**APPLICATION UNDER SECTION 96A OF THE TOWN AND COUNTRY PLANNING ACT 1990 (AS AMENDED)
THE LILIES PHASE 1, SHREWSBURY WEST**

We write further to the granting of the Reserved Matters planning application LPA Ref. 20/01957/FUL, to submit an application for a Non-Material Planning Application under Section 96a of the Town and Country Planning Act 1990 (as amended).

Sales Name: Alderney Classic (Det)

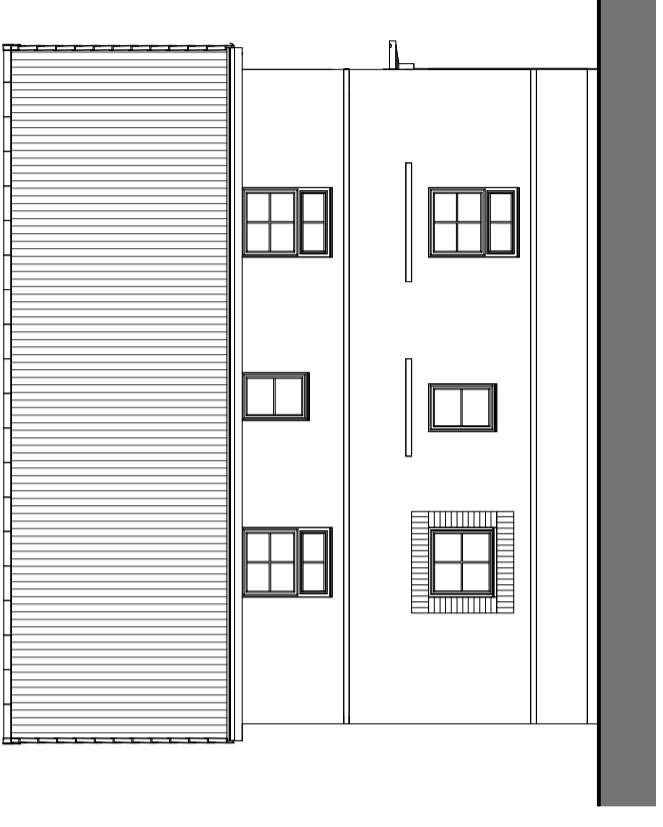
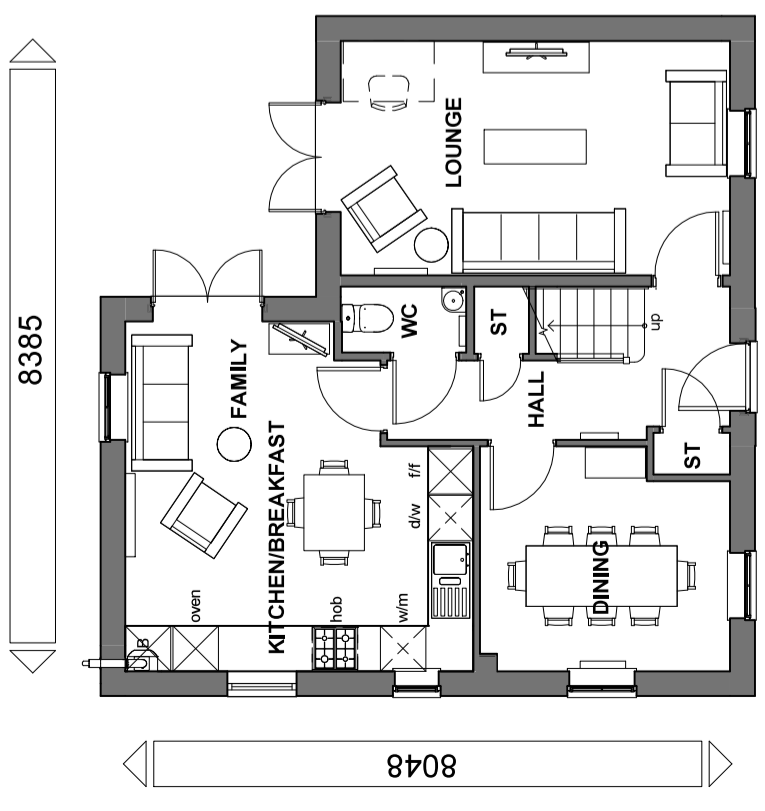
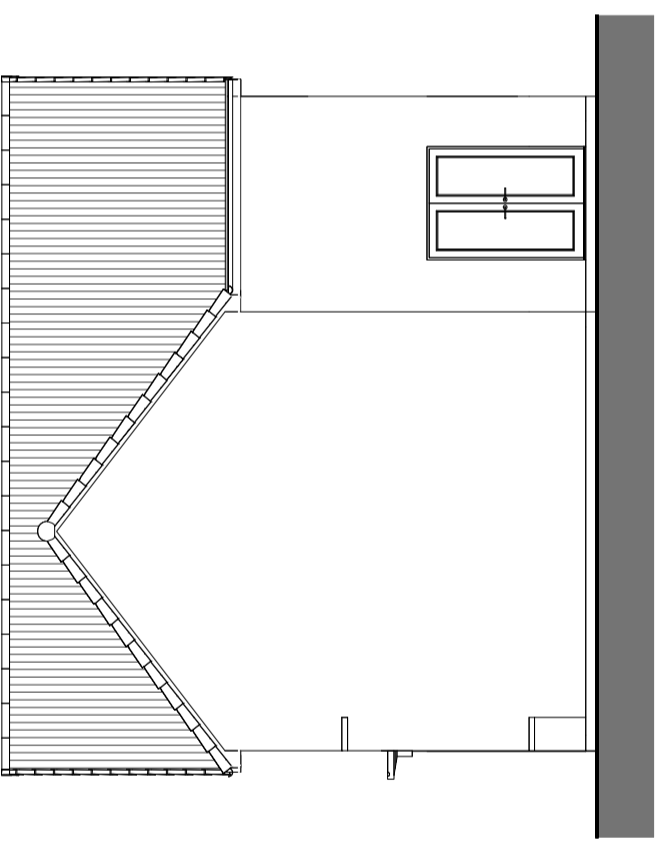
- Plot 326 swapped from an Alnmouth to an Alderney to improve garden size and street scene.
